KIRKLEES METROPOLITAN COUNCIL INVESTMENT & REGENERATION SERVICE

DELEGATED DECISION TO DETERMINE APPLICATIONS FOR CONSENT, AGREEMENT OR APPROVAL REQUIRED BY CONDITION

Reference No:	2023/44/93464/W
Site Address:	Land at, Lingards Road, Slaithwaite, Huddersfield, HD7 5HY
Description:	Discharge of conditions 4 (Phase II report), 5 (Remediation Strategy), 8 (Construction Environmental Management Plan), 9 (CEMP: Biodiversity), 10 (road condition survey), 11 (estate roads), 12 (Lingards Road footway), 13 (highway retaining walls), 14 (highway embankments), 15 (Stability Remediation Strategy), 16 (drainage infrastructure in highway), 17 (drainage scheme), 18 (flood routing), 19 (temporary drainage), 20 (Arboricultural Method Statement), 21 (bridge details), 22 (green retaining wall), 23 (Ecological Design Strategy), 24 (ecological measures), 25 (materials), 26 (footpath connections), 27 (landscaping), 28 (lighting), 29 (temporary waste arrangements), 30 (pedestrian improvements), 31 (pedestrian improvements) and 33 (cycle parking) of previous permission 2020/93954 for erection of 42 dwellings and associated works

DECISION – Discharge of Conditions – Split Decision

THE ROOT PROTECTION AREAS OF T3 AND T4 HAVE BEEN OFF-SET IN ORDER TO TAKE INTO CONSIDERATION THAT THEY ARE GROWING IN AN ELEVATED LOCATION ON A RAISED STONE FEATURE

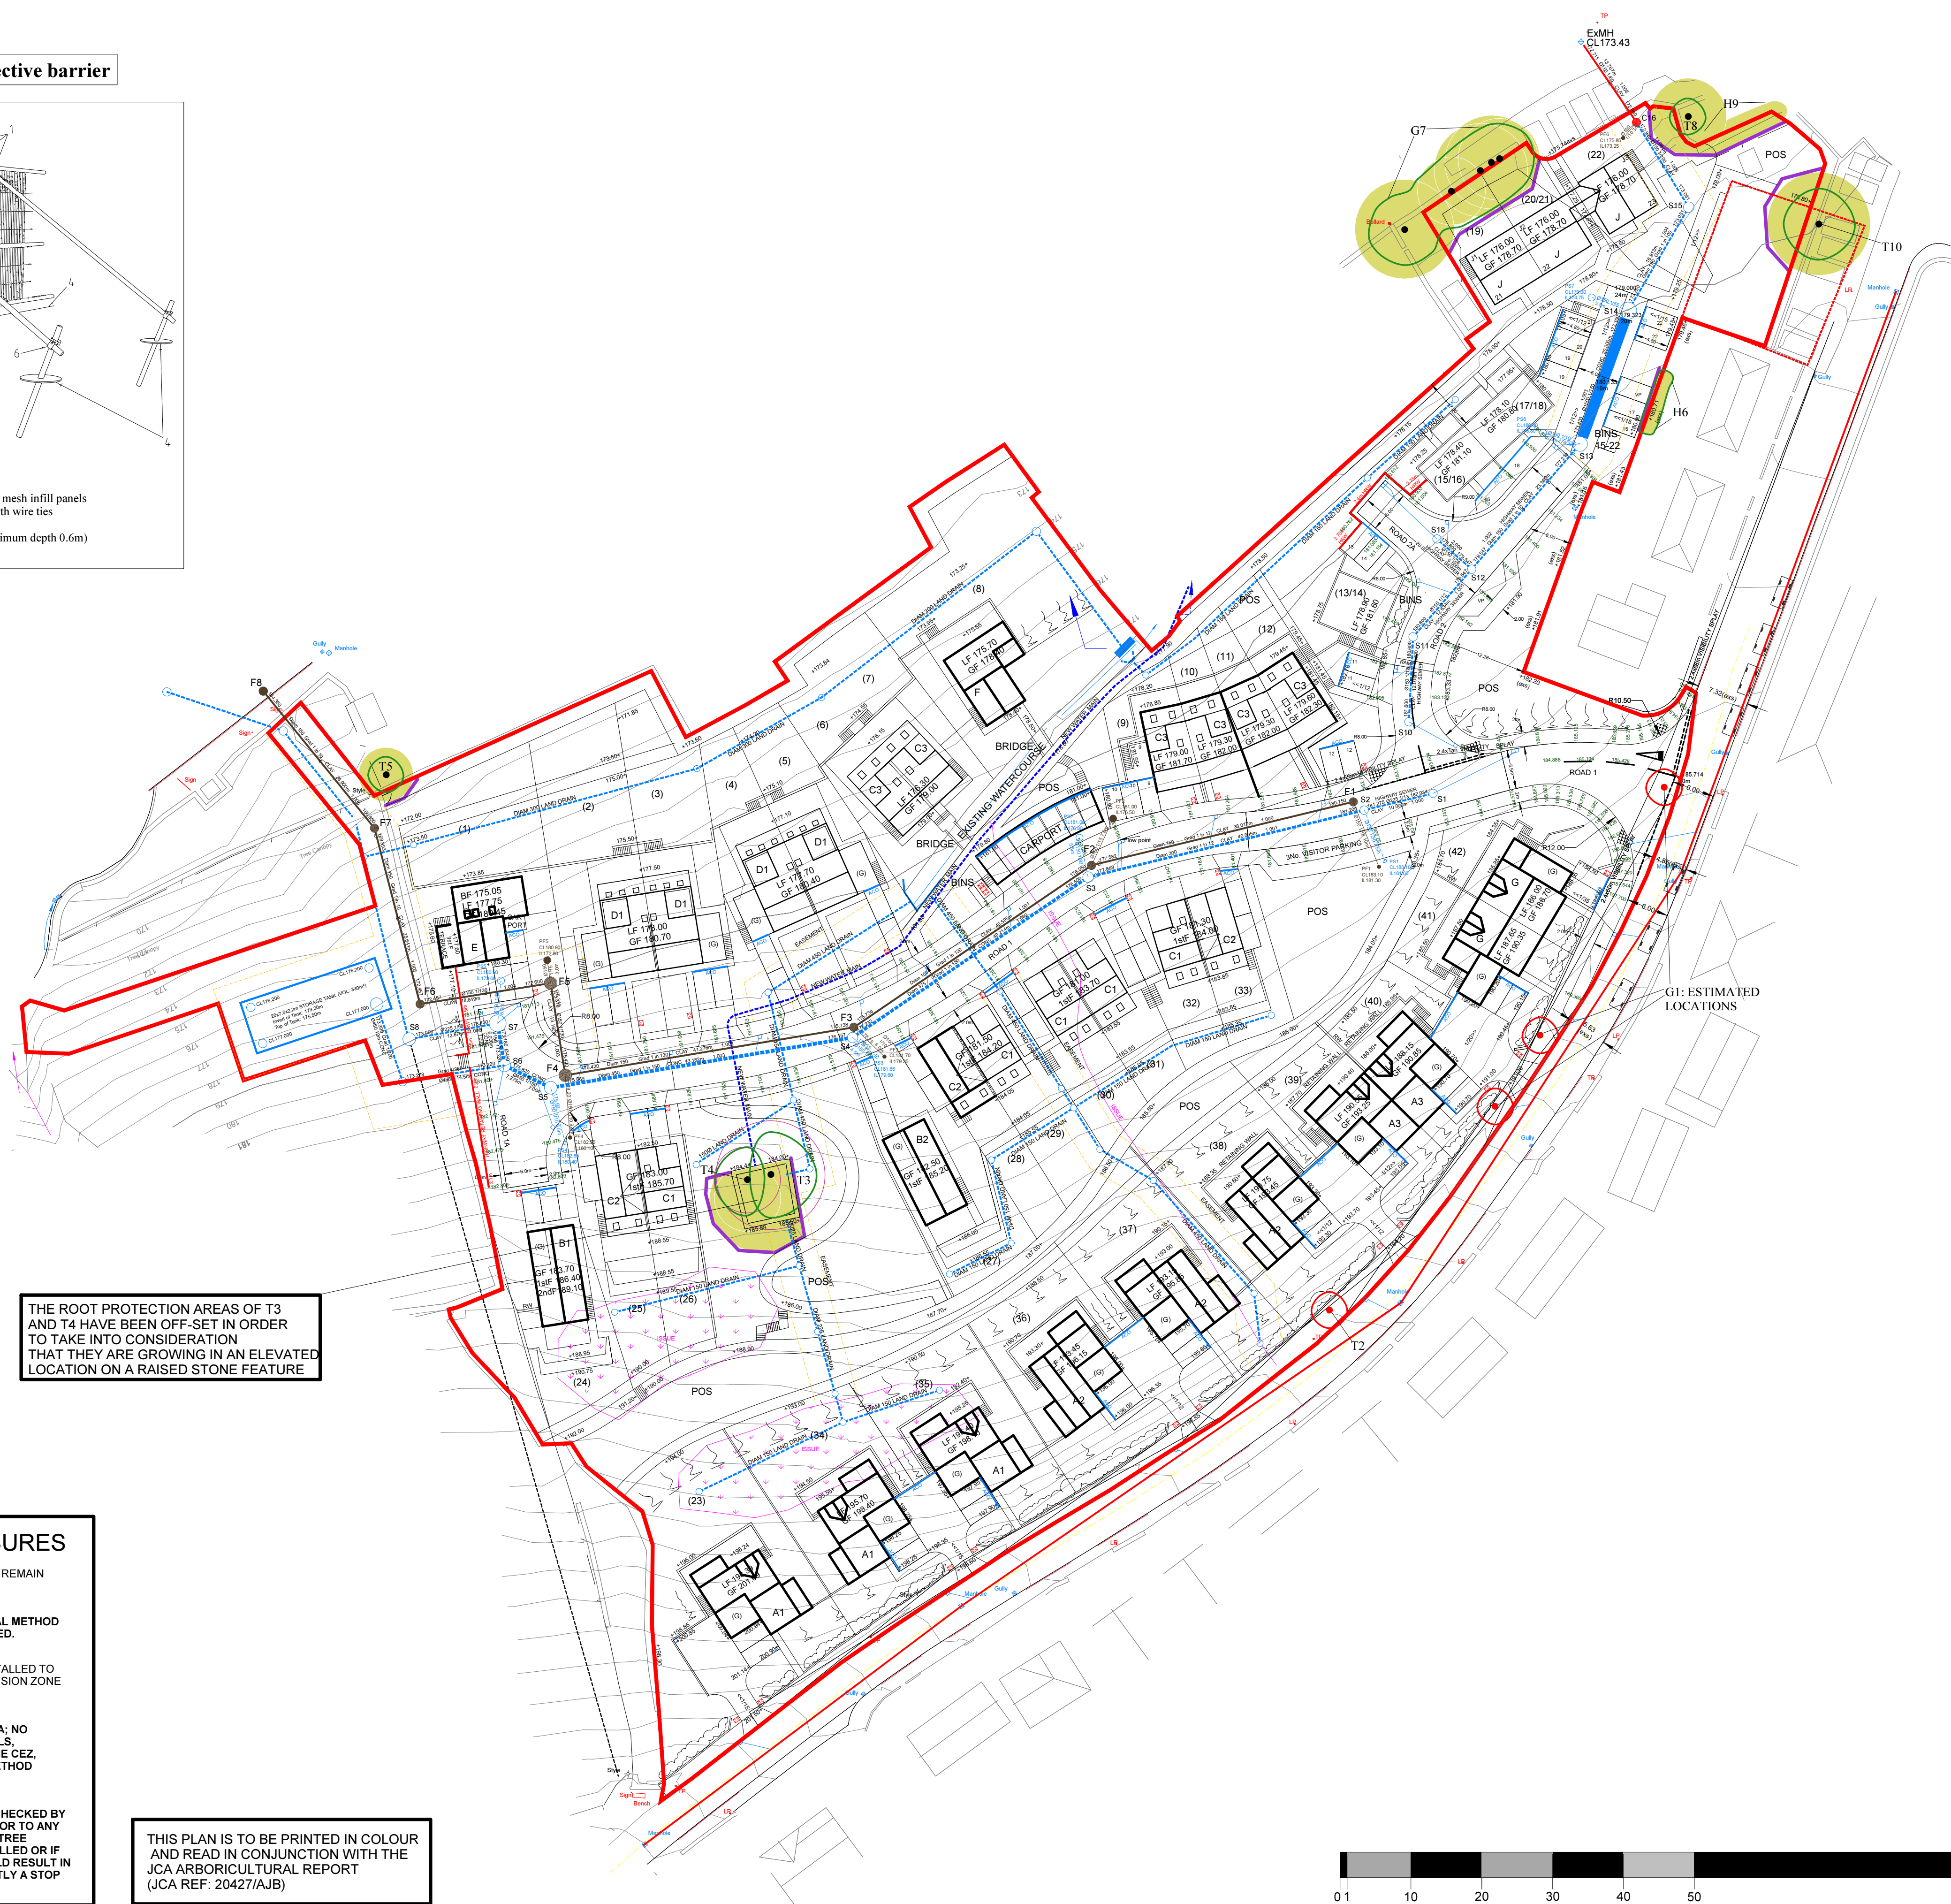
- The proposed protection fencing around T3 and T4 isn't acceptable. There is a requirement to protect the overhanging canopies of trees where they could be damaged by machinery, vehicles, barriers or scaffolding, where it will be necessary to increase the extent of the tree protection barriers to contain the canopy (BS5837:2012 5.2.3.e). It is likely the canopies of T3 and T4 will be vulnerable to damage by machinery and vehicles to a point that their canopy spread should be encompassed with default specification tree protection fencing as shown in Appendix 2: Protective Barrier of the AMS.

- Considering the trees T3 and T4 are within a POS and the value of T3, it would be good to protect the nominal RPA of the trees with fencing as shown in Appendix 2: Protective Barrier of the AMS and then treat it as sacrosanct.

- Section 4.3 of the AMS is not correct. New hard surfaces are proposed within the RPA of T10 based on the TPP plan.
- Lastly, conditions 16 (drainage infrastructure in highway), 17 (drainage scheme) and 19 (temporary drainage) are being discharged too as part of this application. Since details on service routes are not available at the time the AMS was written the AMS needs amendments. It would be good for these details to be provided to the project arboriculturist so they can be included for consideration within the revisions.

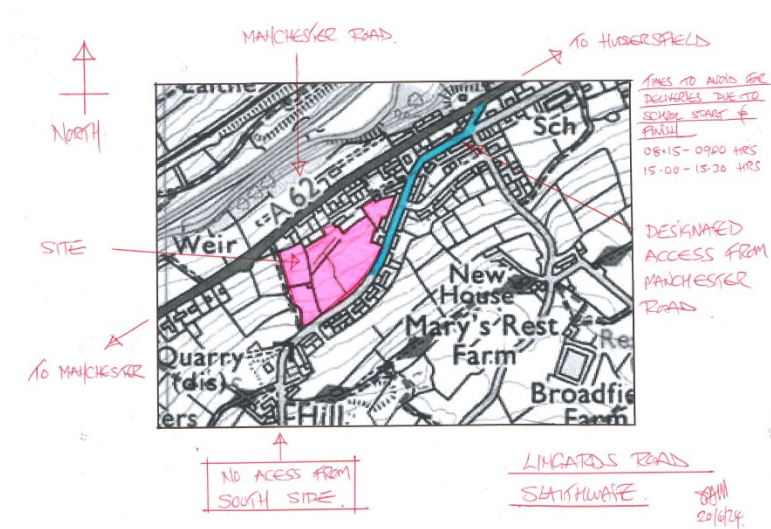
d) A plan showing routing from Manchester Road should be provided. Explicit reference to there being no access from Chain Road to the south of the site should be provided. Elaboration on the expected construction vehicles accessing the site should be provided and their numbers / frequency. Timings of vehicle movements should be provided and avoid aligning with school start / finish (which should be researched and confirmed in the report).

e) No details of typical expected vehicle movements or sizes have been provided.
